An
Coimisiún
Pleanála

Direction
CD-022087-26
ABP-321395-24

DRAFT WORDING FOR ORDER

PROPOSED BUILDING ELEVATIONS AND PLANS

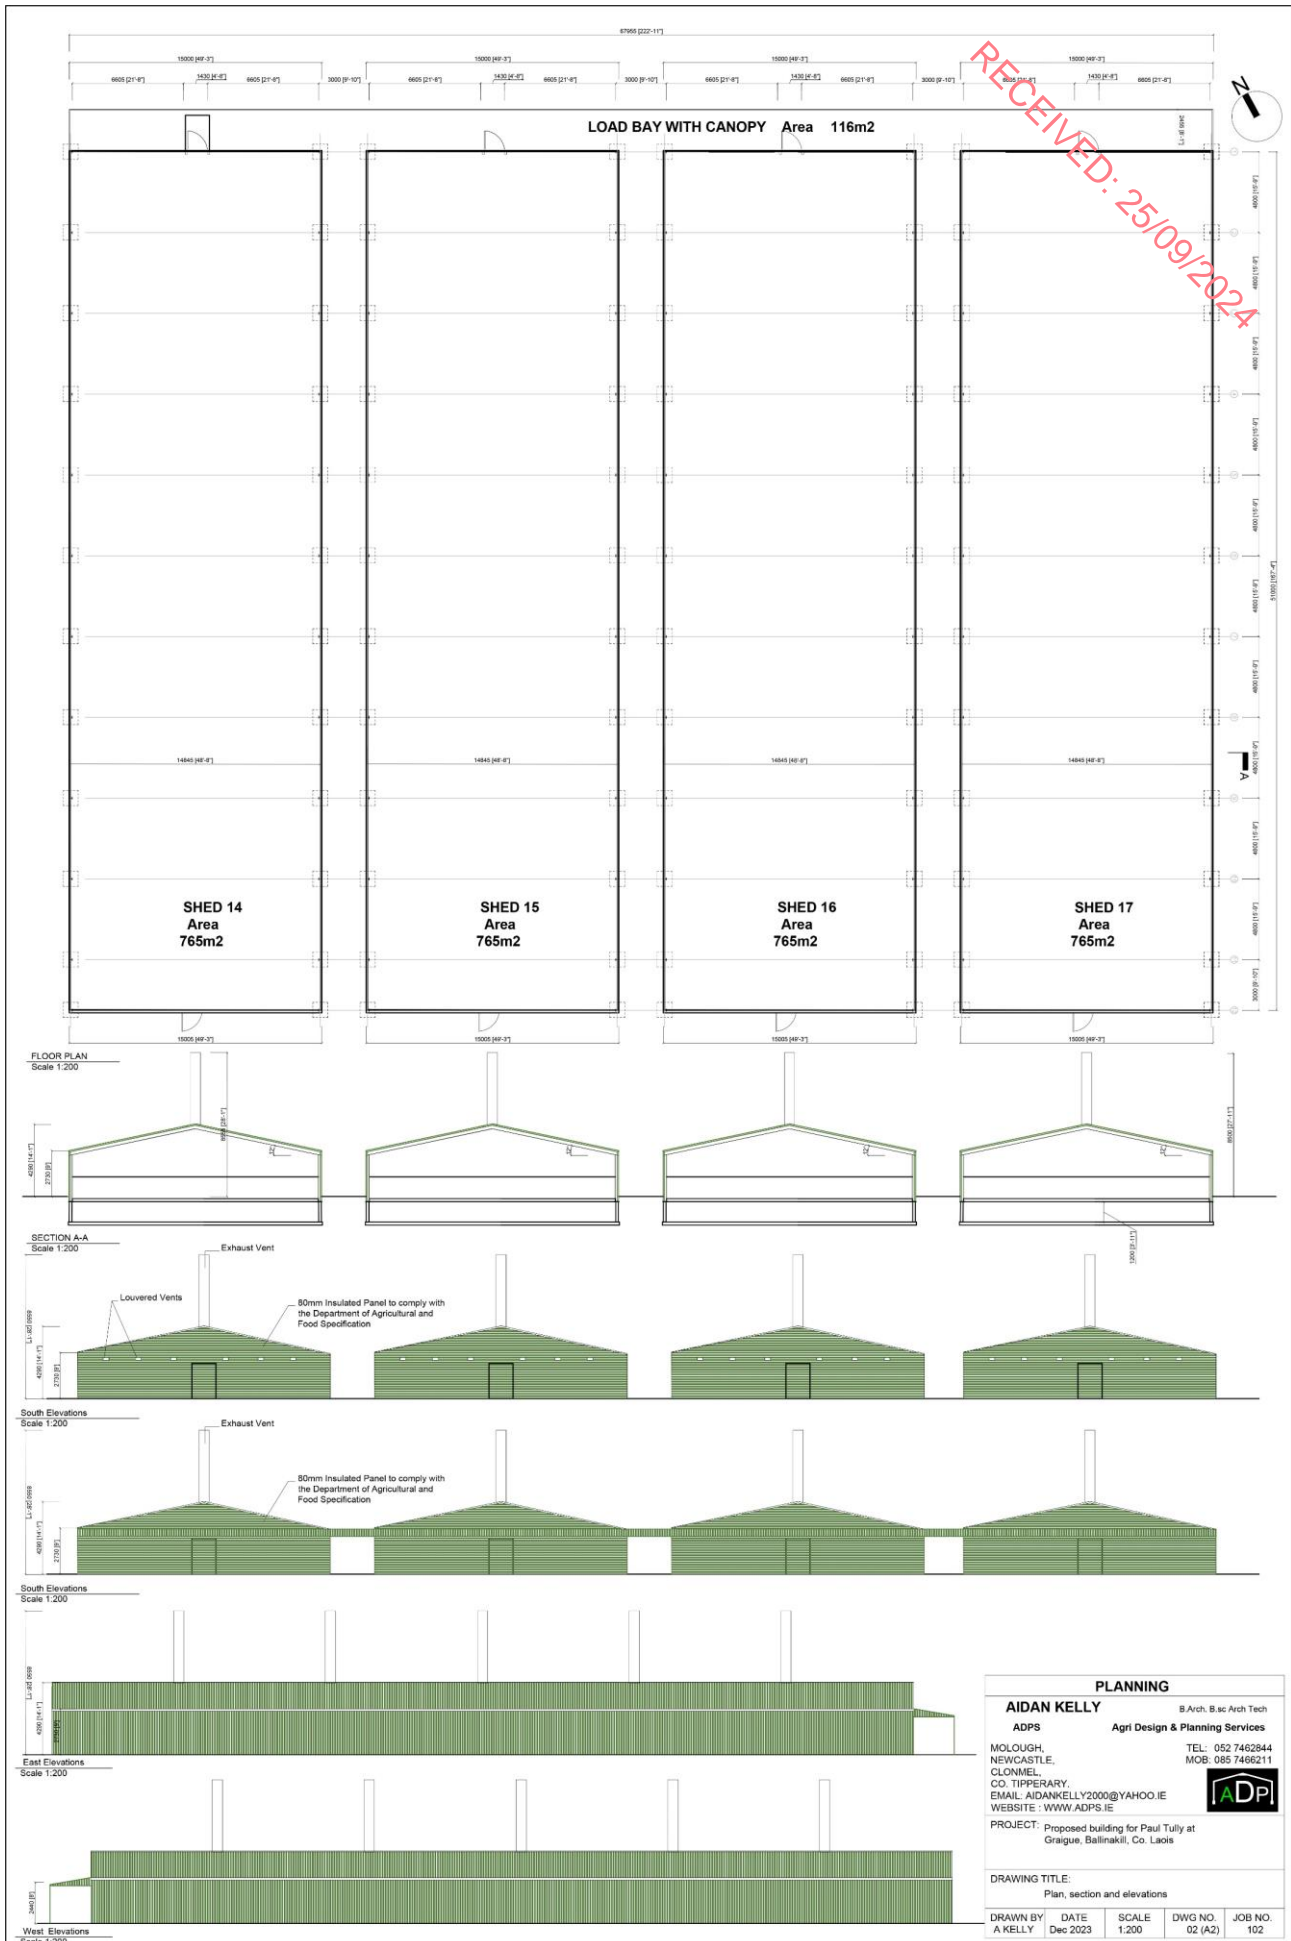
2. The proposed development shall be amended as follows
 - a) The proposed feed bins shall be finished in a dark green colour.
 - b) External lighting shall be cowled and directed away from the public road.

Revised drawings showing compliance with these requirements shall be submitted to, and agreed in writing with, the planning authority prior to commencement of development.
